M25 junction 10/A3 Wisley interchange TR010030

9.154 Applicant's comments in response to the submissions of the Royal Horticultural Society on Habitats Regulations Assessment matters

February 2021

Figure 1: Wisley & Ockham Commons Management Plan 2010 – 2020 management prescriptions for woodland clearing / felling shown with the 150m buffer zone from the roads

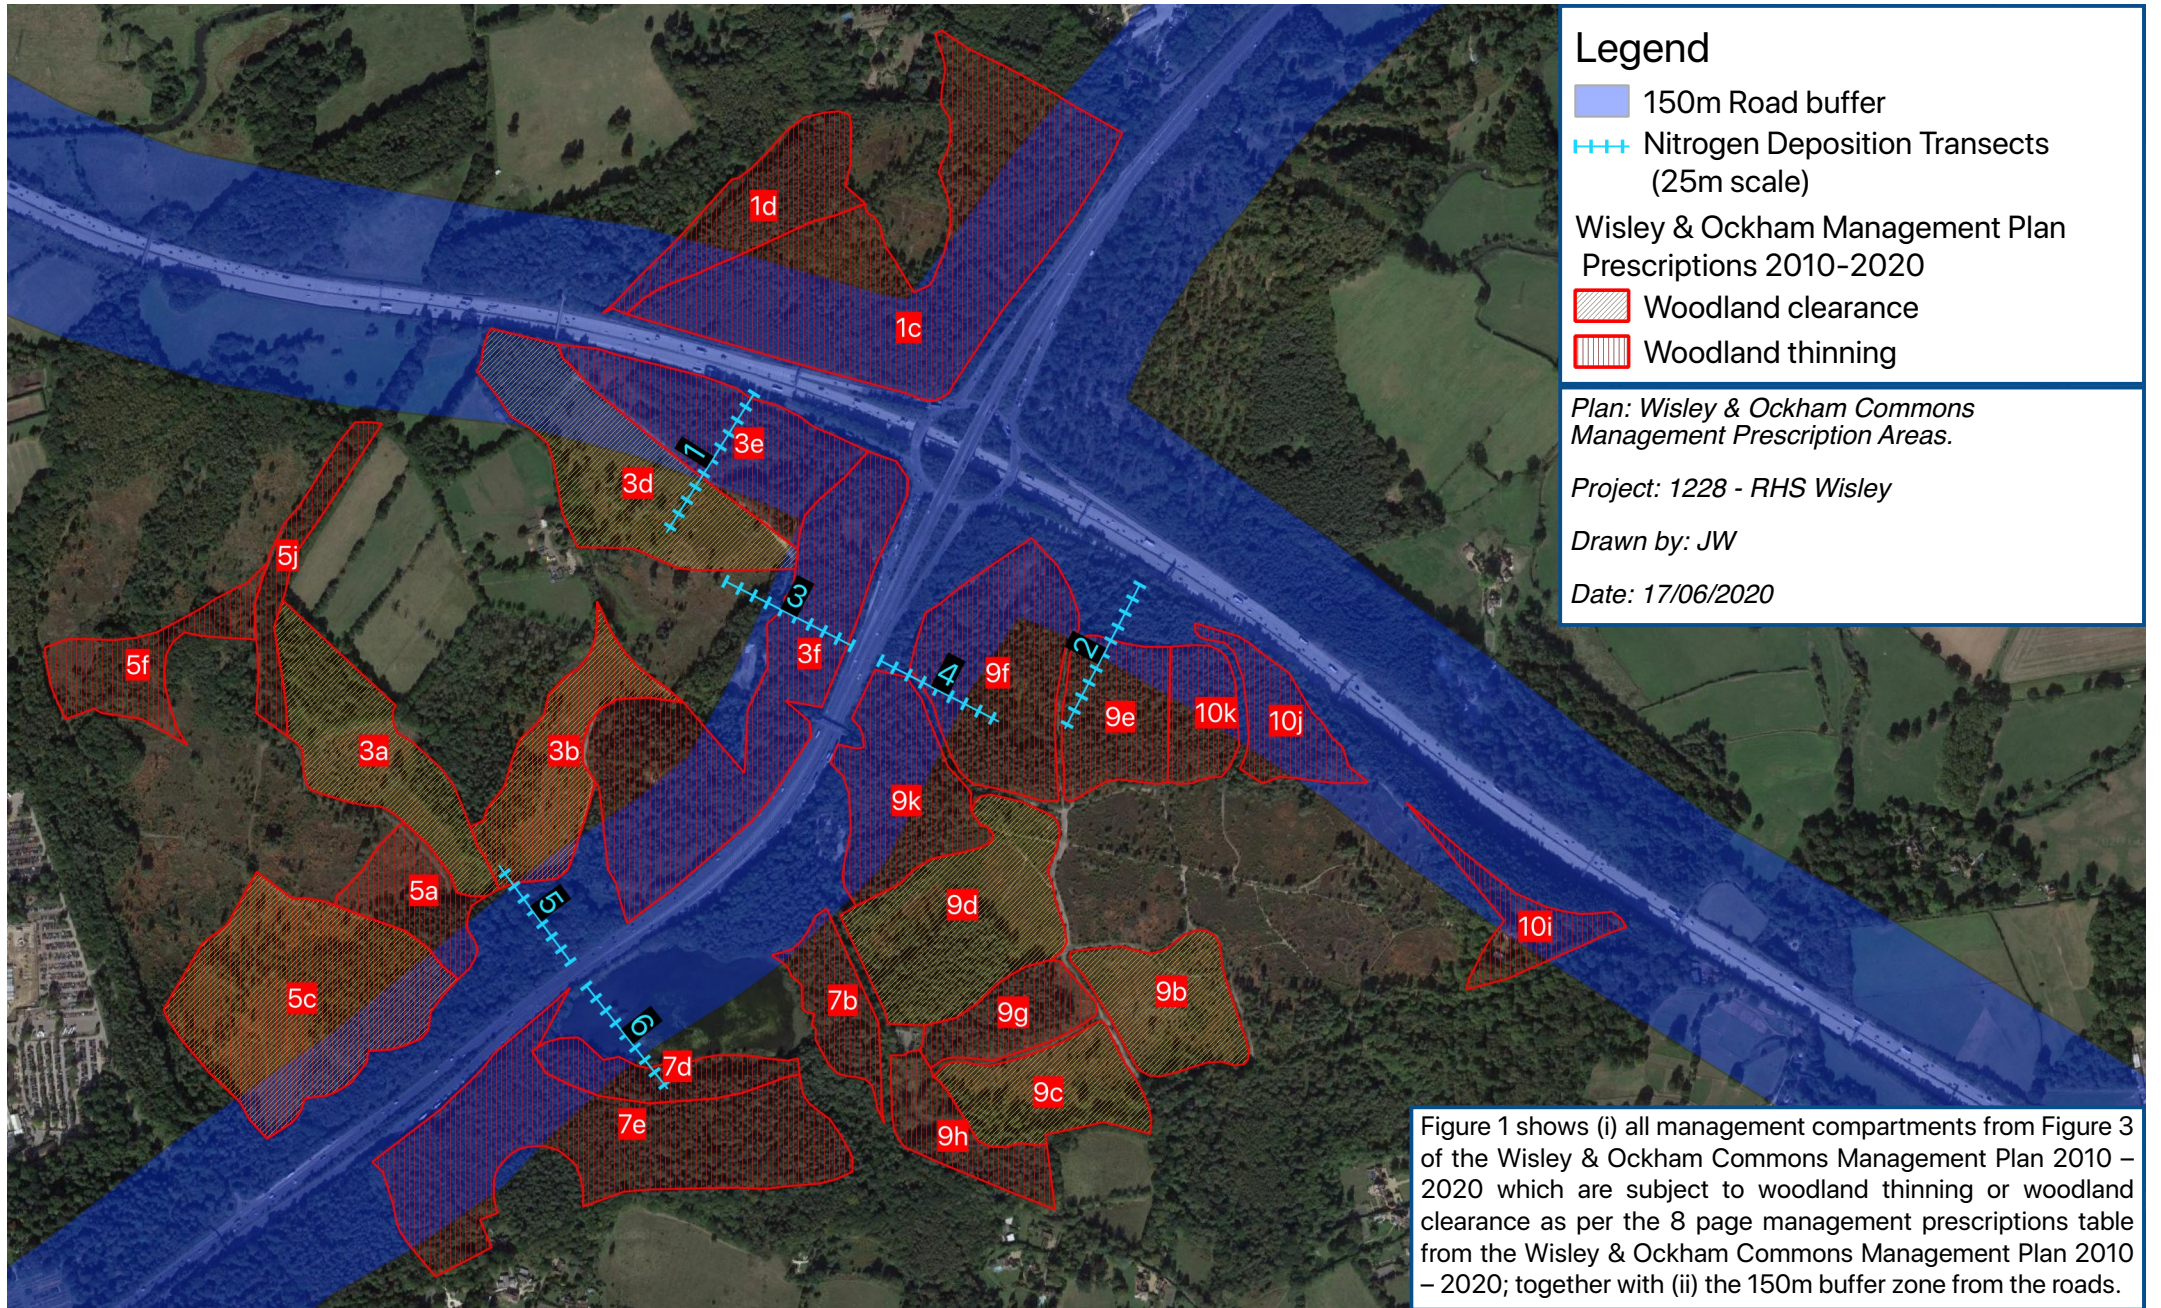
- 2.2.11 This is further supported by RHS's own consultants' (Baker Consultants Limited) Figure 1 [REP11-042], which shows the general areas proposed for woodland clearance, as set out in the Surrey Wildlife Trust 2010-2020 Wisley and Ockham management plan [REP10-019]). Being extremely familiar with the site, Mr Watts's evidence is that large areas of woodland clearance have indeed taken place within all of these proposed locations for woodland clearance (3a, 3b, 3d, 5c, 9b, 9c and 9d) in recent years (i.e. as a result of this management plan). It is very obvious when out on site that Surrey Wildlife Trust have indeed completed the felling works that they intended for these general locations, as they have stated in their final comments [REP12-043].
